Engineers Comments Regarding Surface Water Drainage

Application Reference:	A/20/26/DOC	Reviewer Reference:	ADC/EXT5/AF
Planning Officer:	Jessica Riches	Date of Review:	26/02/2026
Site Name:	Land North of Water Lane Angmering BN16 4EJ		
Application Description:	Approval of details reserved by condition under A/248/21/PL relating to condition 29 -As Built Drainage.		
Assessment Number:	1

-Angmering Phase 2 Drainage Verification Report v2 Part 1. Ref: 5968-002.001. February 2026, uploaded in 8 parts via the public planning portal

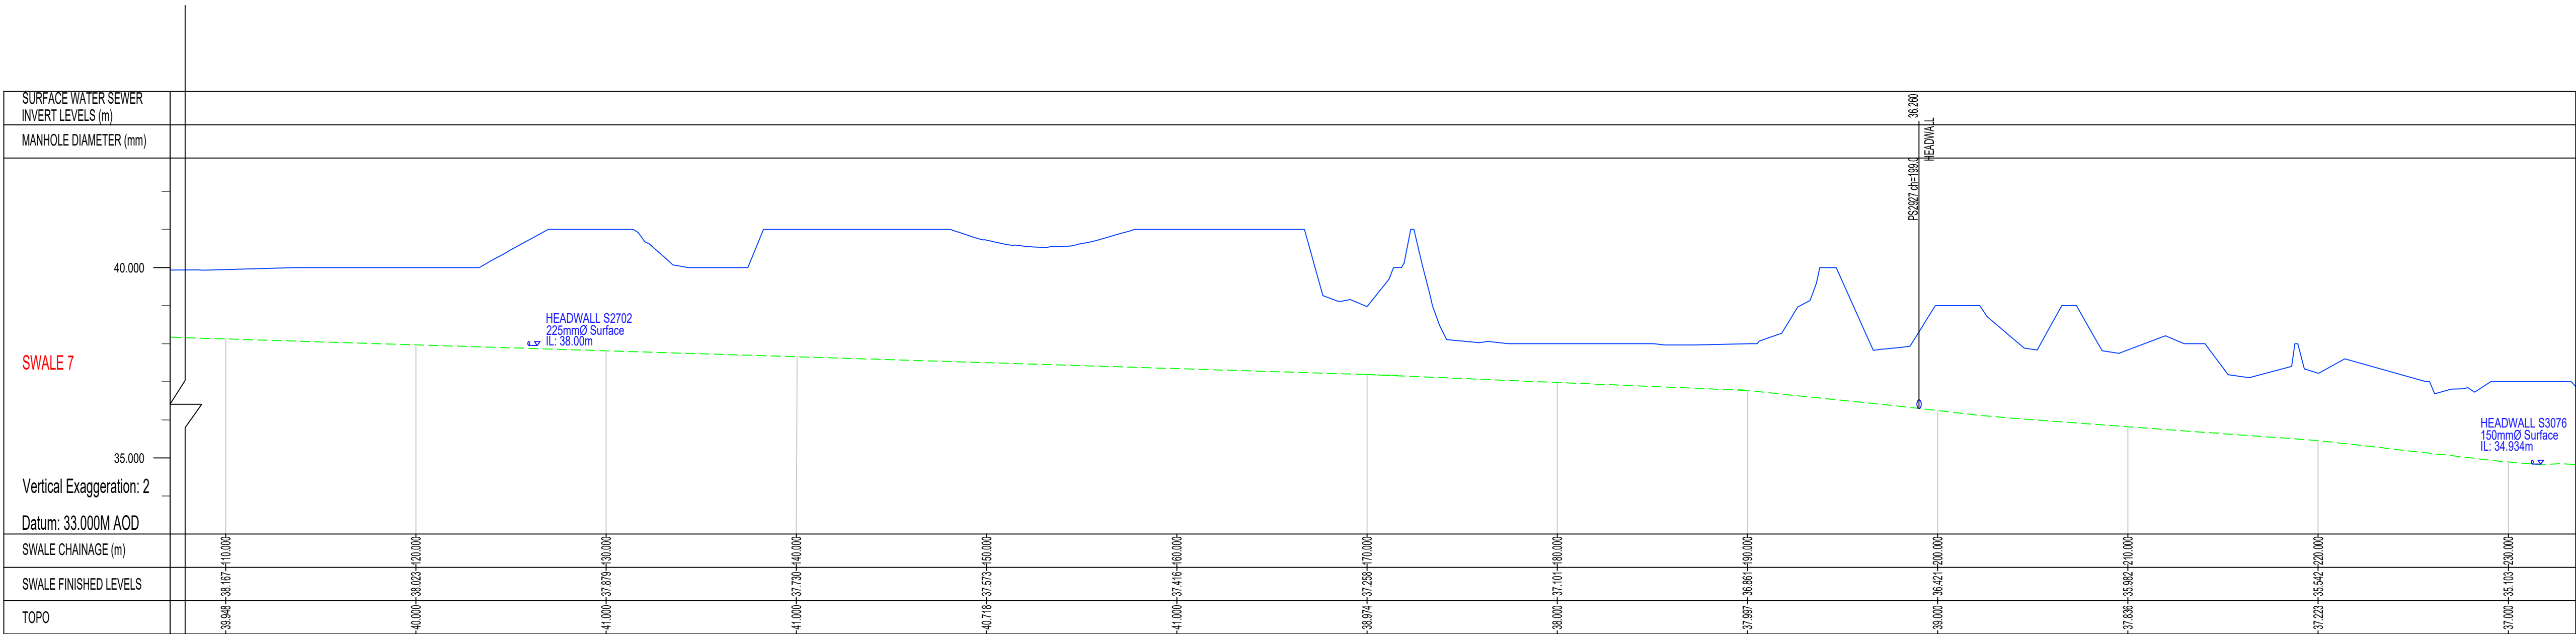
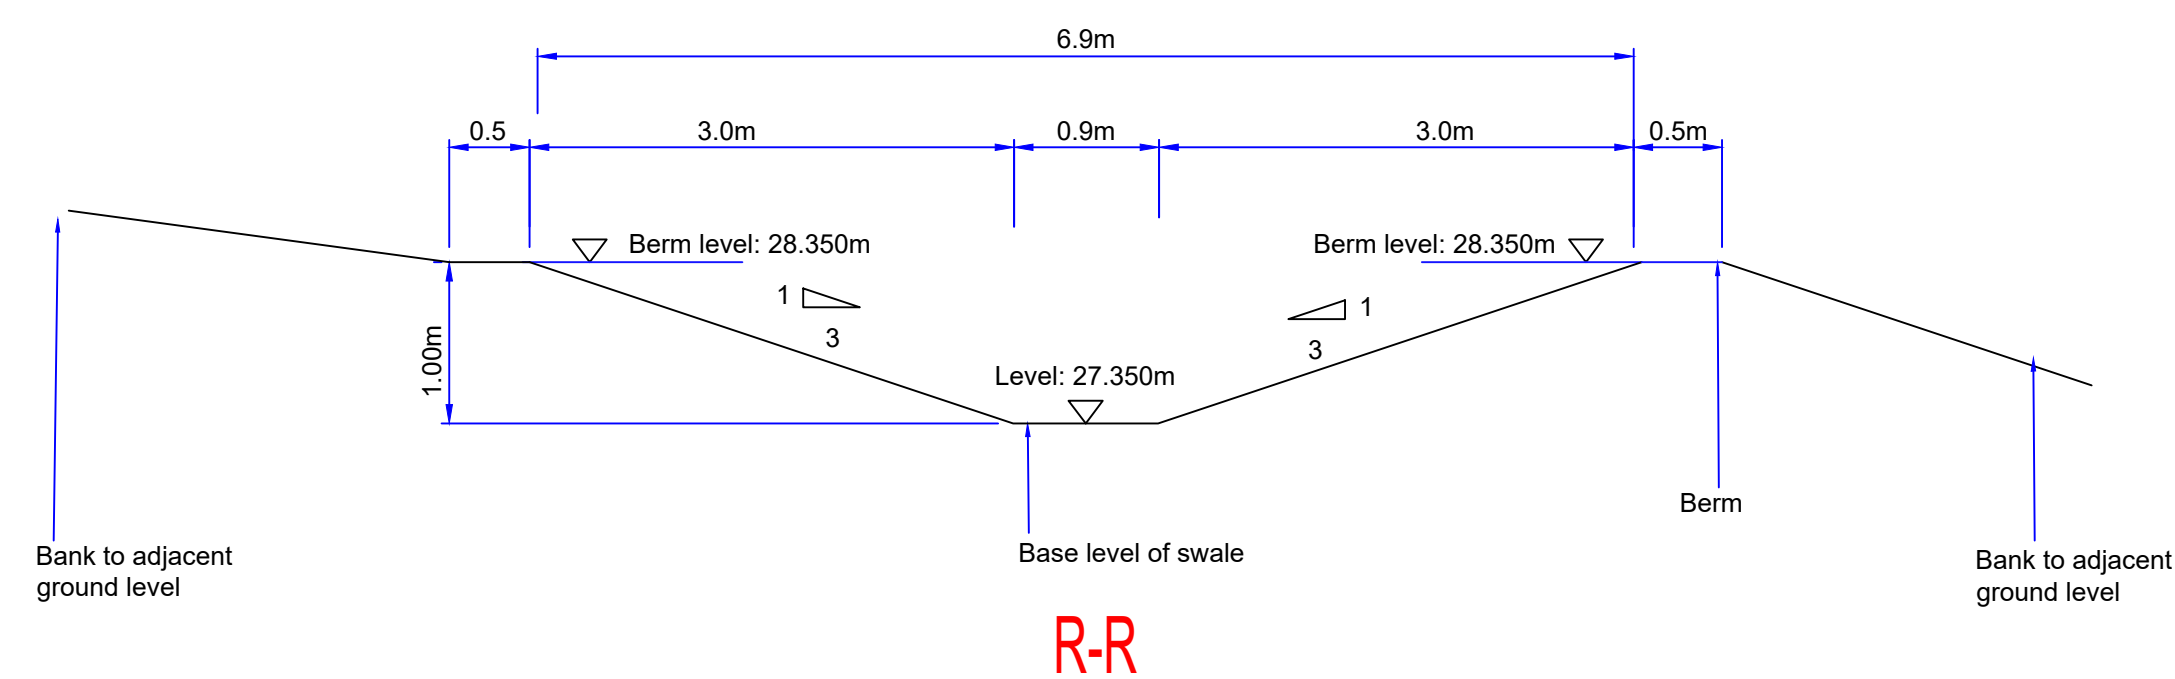
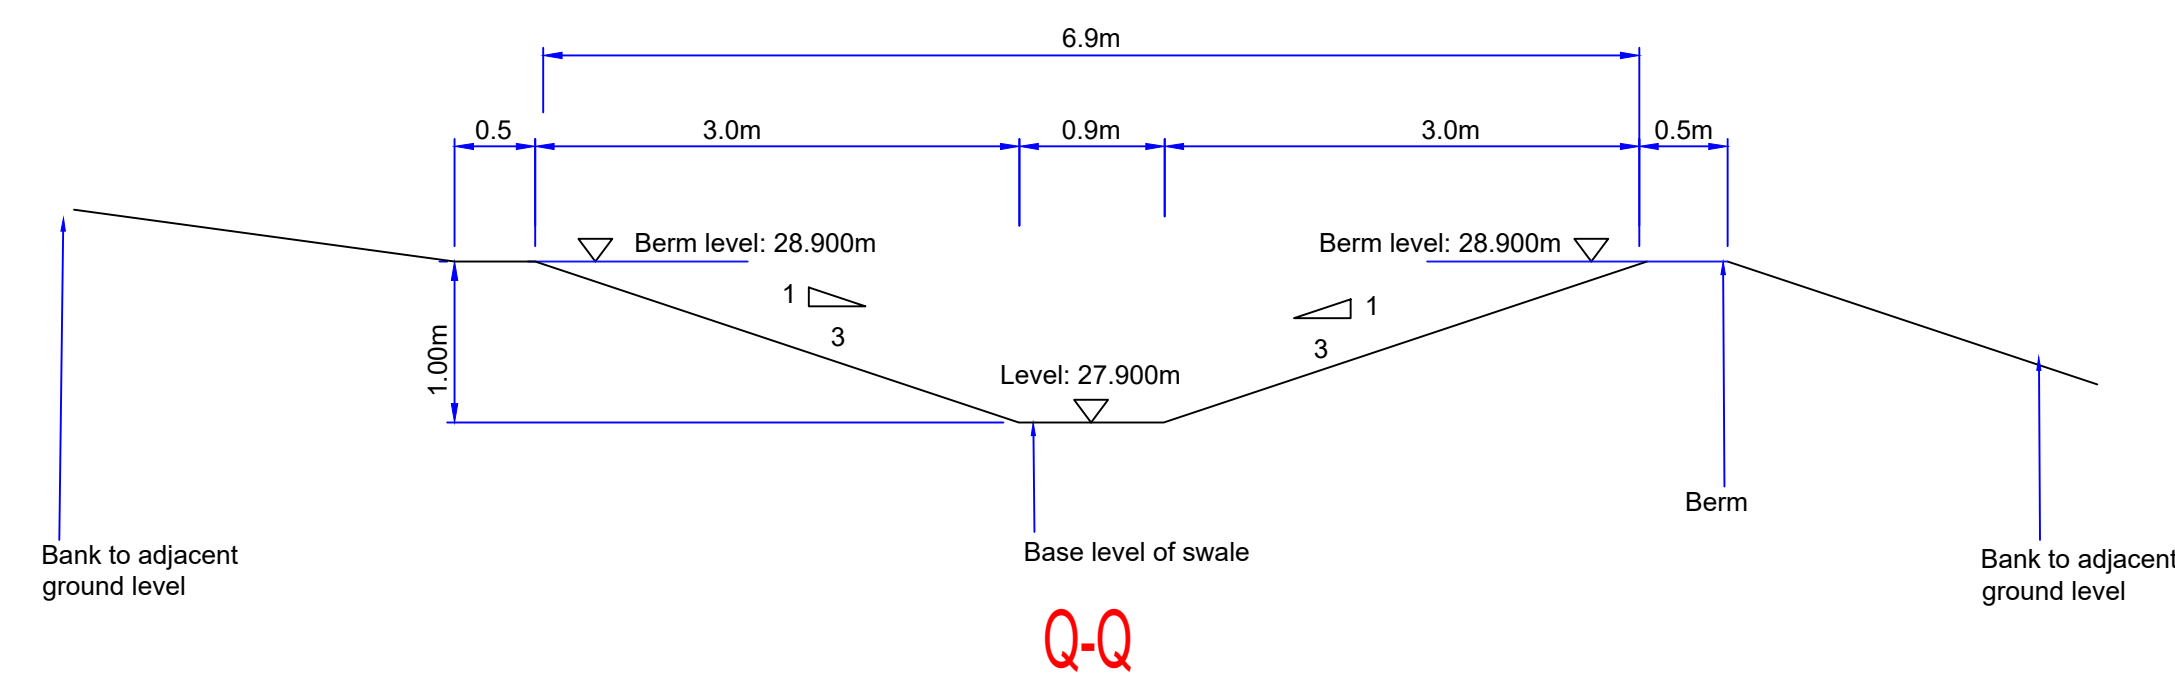
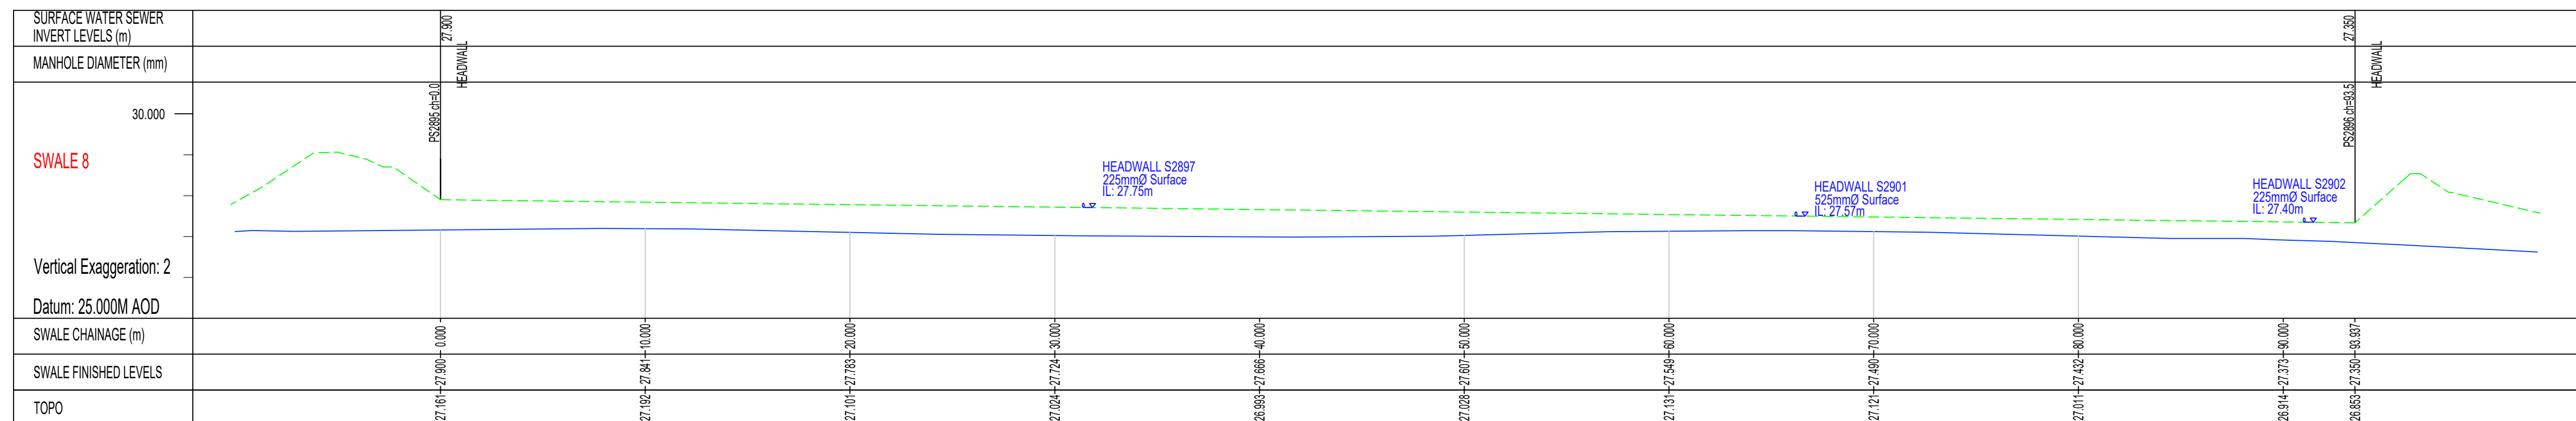
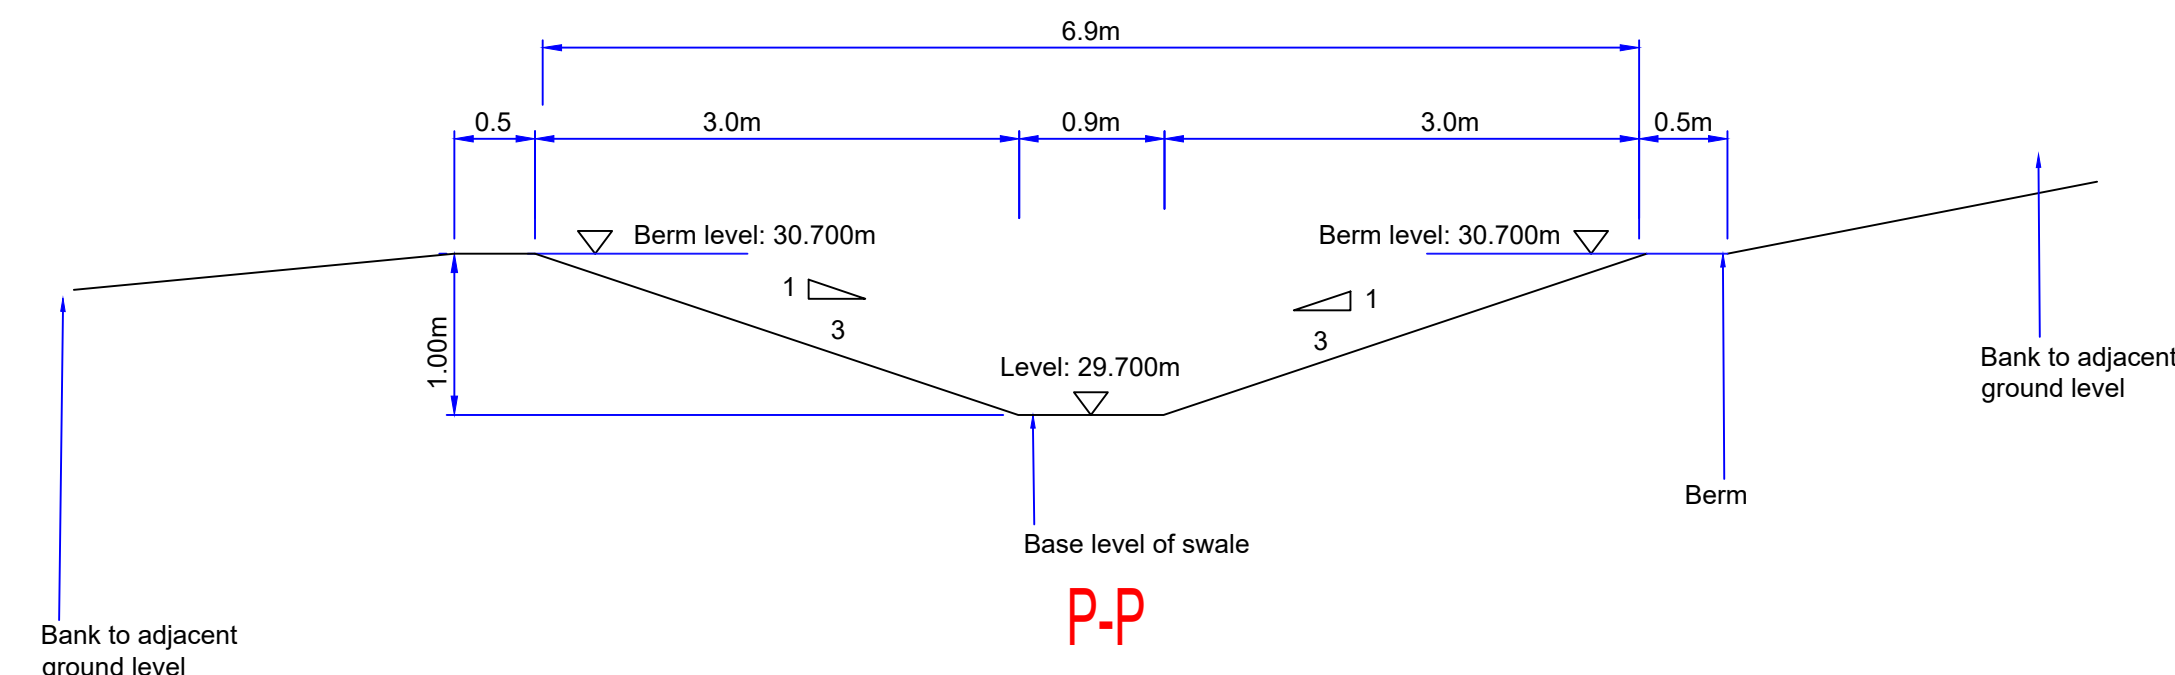
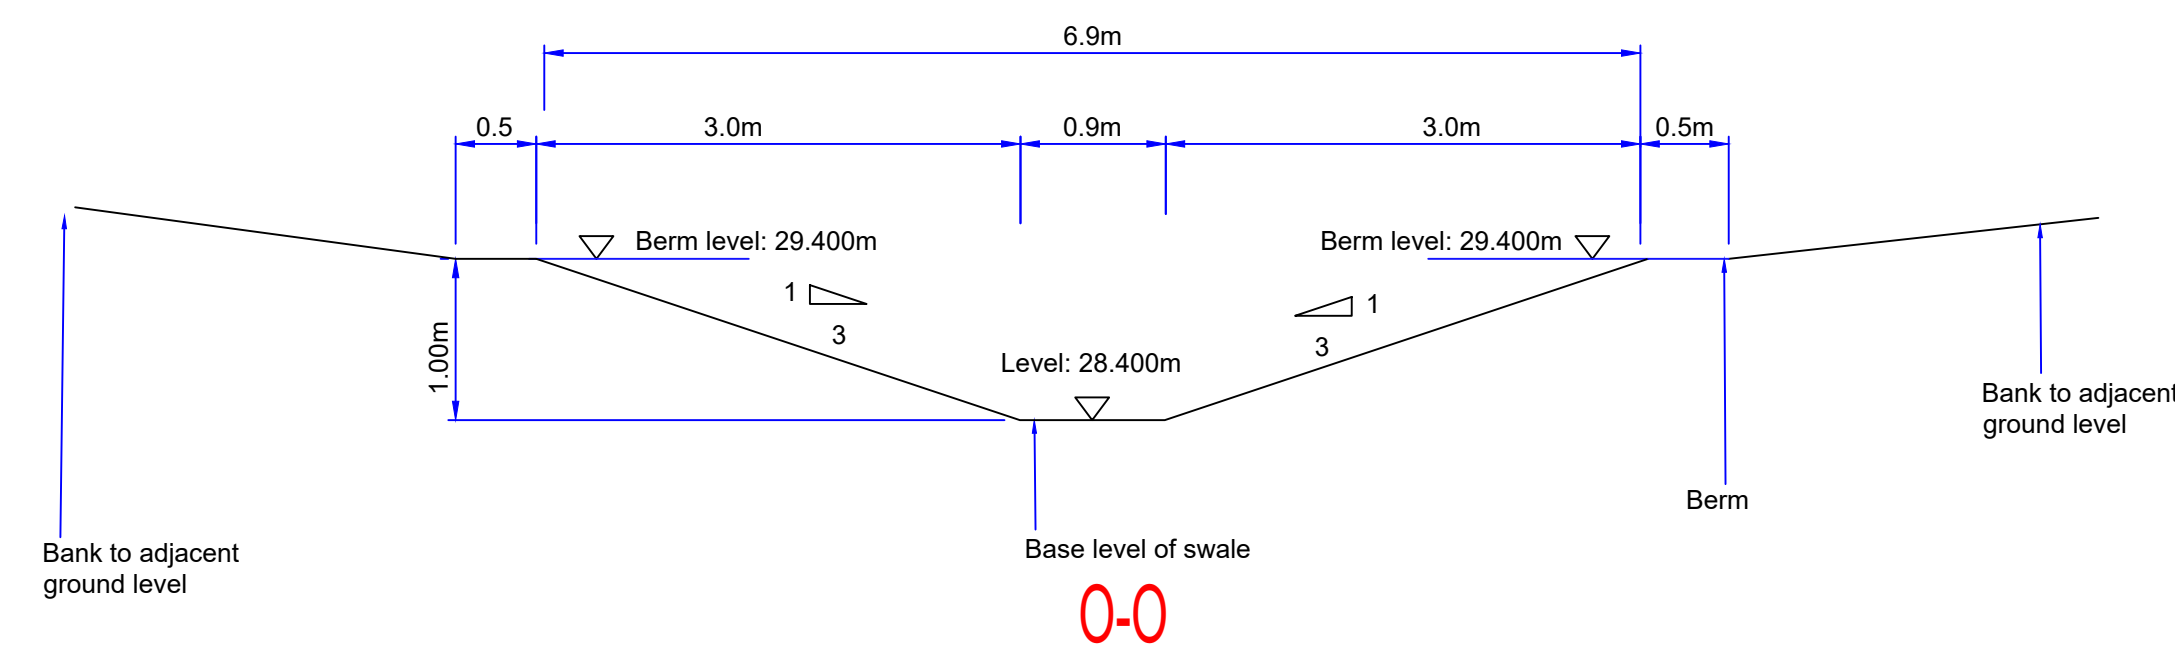
5.	The swales include storage provision and/or design storm flows as part of the sustainable drainage system. An as built measured survey should be provided and confirmation through volumetric comparison with the approved technical design that the as built capacity is fit for purpose.	The volume of the constructed swale has been calculated and can be found in Appendix M. The proposed Drainage Layout states that 17.3m3 of storage is required in this swale to manage the surface water runoff in a 1 in 100 year + 40% climate change storm event, therefore the constructed basin provides greater storage volume than required.
